As per your comments for the above application would you consider what the applicant has outlined below or do you stick 100% to what you have written within your report?

Thank you for the below email and the proposal from the tree officer. We have reviewed the proposed alternative scope of works on site and would like to request a slight adjustment to the lateral spread measurement in T1 & T2 to 6.5m as indicated below in green text.

T1 & T2 - Reduce radial spread by no more than 1.5m. In any event, a minimum of ~~6.5 metres~~ **7metres** lateral spread when measured from the main stem must remain. Crown lift by removal of/reducing small diameter branches (<100mm) to achieve a maximum of 4metres overhead clearance.

Plan showing location of trees

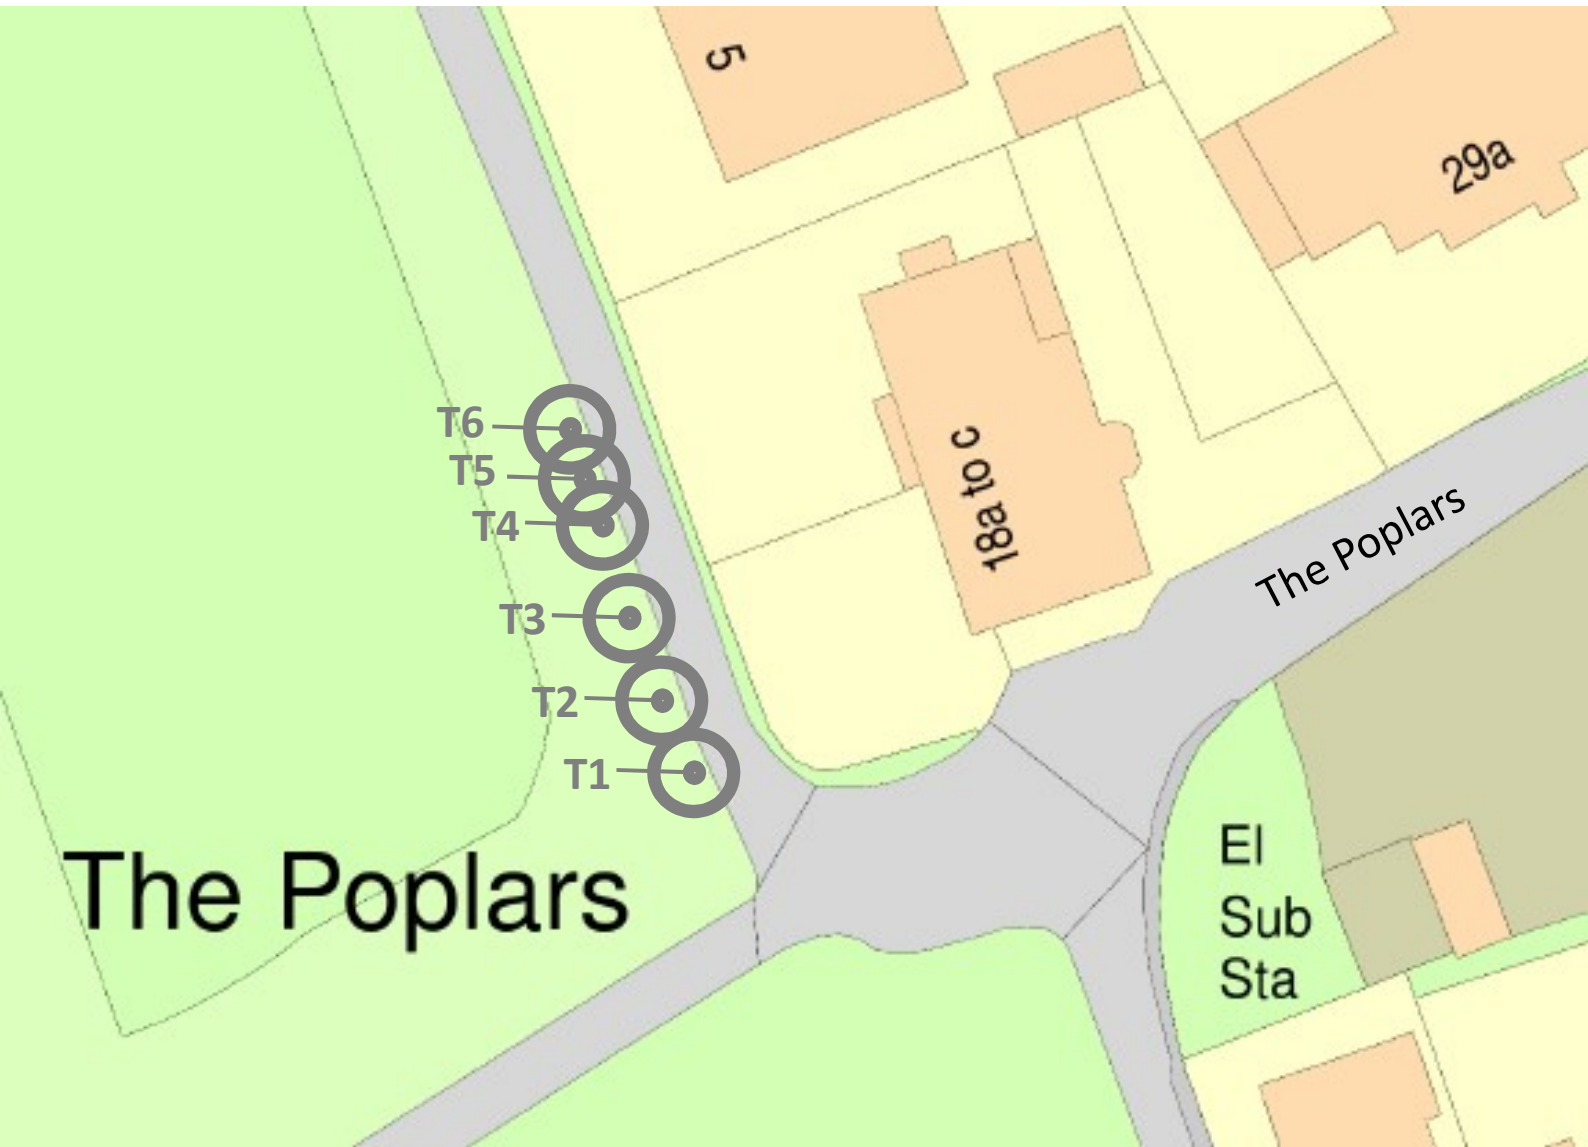
Within the 4m overhead clearance zone, T1 & T2 currently protrude into the neighbouring garden by circa 3.5m. This is a result of the neighbouring property boundary being 4.2m from the main stem and the current maximum radial spread from the main stem being approximately 7.5 and 7.7 metres.

The 0.5m adjustment to 6.5m will enable the lower, smaller stems (<100mm) that currently measure between 7.5m and 7.7m from the main stem to be reduced horizontally by approximately 1m within the 4m overhead clearance zone.

I am happy to agree to the slight revision proposed by the applicant.
